CITY OF ALBUQUERQUE

**Re: Ventana Ranch Commercial Development
Traffic Impact Study**
Engineer's Stamp dated January 11, 2021 (B10D003C3)
Received 1/12/2021
CABQ Planning Transportation re-issued approval

The subject Traffic Impact Study for the Ventana Ranch Commercial Development (NE quadrant of Paseo del Norte Blvd. and Universe Blvd.) dated January 11, 2021 has been accepted and approved by the Transportation Development Section.

SHEET TITLE: SITE PLAN

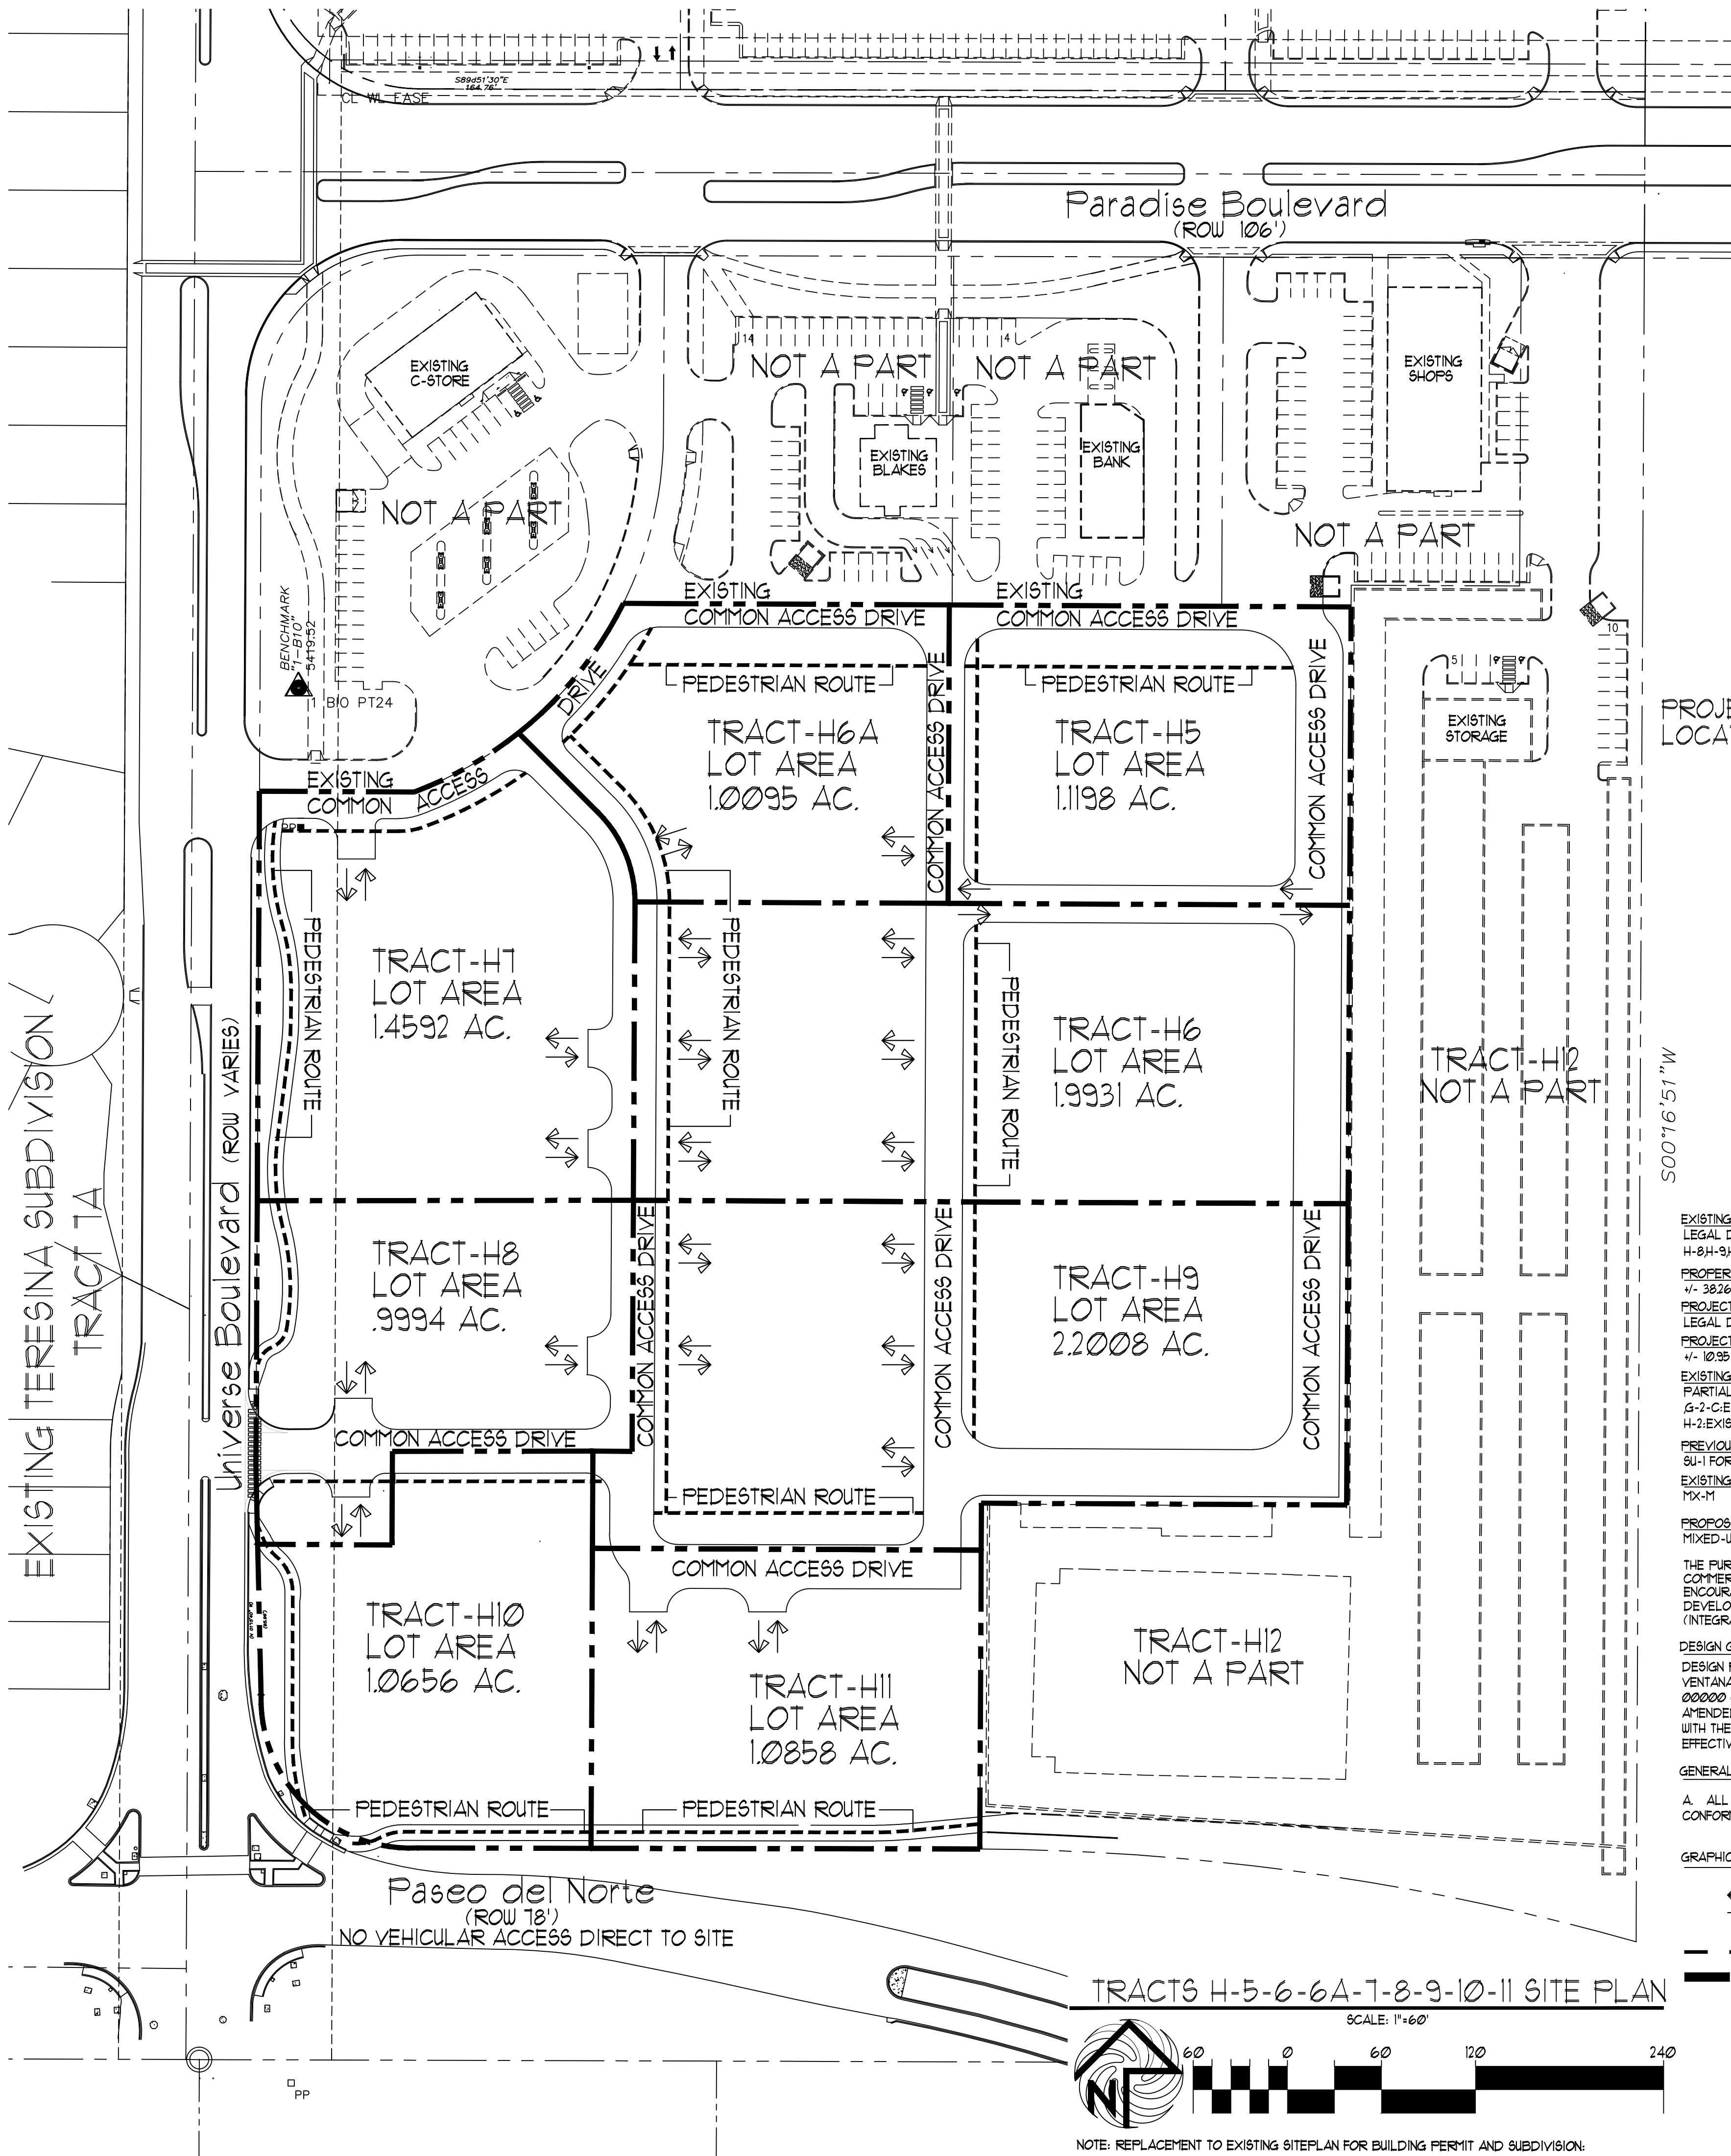
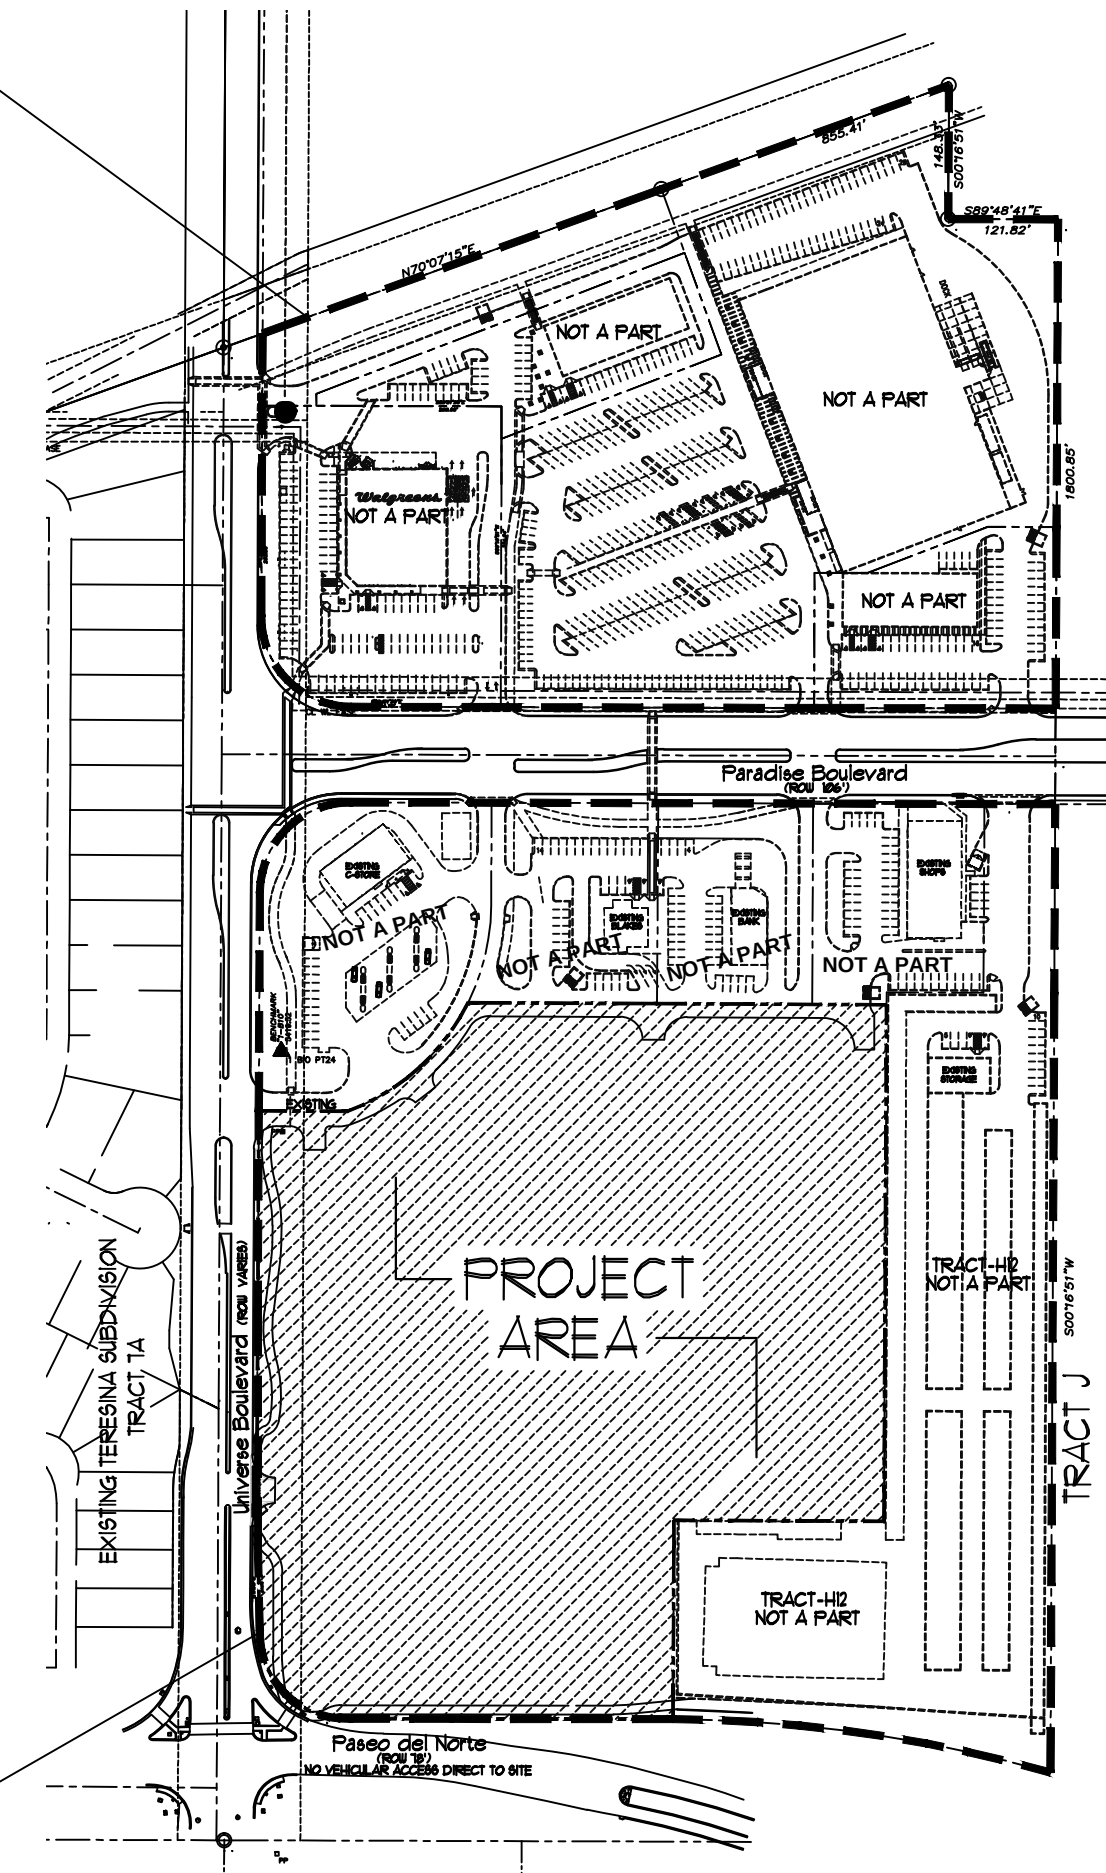
1. Driveway 7, Paradise Blvd. East Driveway: An eastbound right turn deceleration lane is warranted based on the right turn volumes alone. However, there is insufficient right-of-way to construct a right turn lane. The right turn lane is not recommended at this time. When Paradise Blvd. is reconstructed a right turn lane should be considered. Cost for the construction of a right turn lane should be shared between the existing businesses and the proposed development.

2. Driveway 8, Paradise Blvd. West Driveway: An eastbound right turn deceleration lane is warranted based on the right turn volumes alone. However, there is insufficient right-of-way to construct a right turn lane. The right turn lane is not recommended at this time. When Paradise Blvd. is reconstructed a right turn lane should be considered. Cost for the construction of a right turn lane should be shared between the existing businesses and the proposed development.

3. Driveway 9, Universe Blvd. North Driveway: A northbound right turn deceleration lane is warranted based on the No Build right turn volumes alone. It is recommended that a right turn deceleration lane be constructed at Driveway 9. It is estimated that the maximum length attainable is 100 feet long plus transition. the developer will dedicate an easement or grant right-of-way (11 feet wide) in which to construct the right turn deceleration lane. Cost for the construction of the right turn lane and driveway modifications will be borne by the developer.

4. Driveway 10, Universe Blvd. South Driveway: Construct a full access two-lane driveway with a northbound right turn deceleration lane. This right turn lane is warranted based on the BUILD right turn volumes. The required length of 240 feet plus transition cannot be achieved since the proposed south driveway is too close. It is recommended that a 100 feet long taper lane be constructed on Universe Blvd. at Driveway 10. The developer will dedicate an easement or grant right-of-way (11 feet wide) in which to construct the right turn deceleration lane. Cost for the construction of the right turn lane and driveway will be borne by the developer.
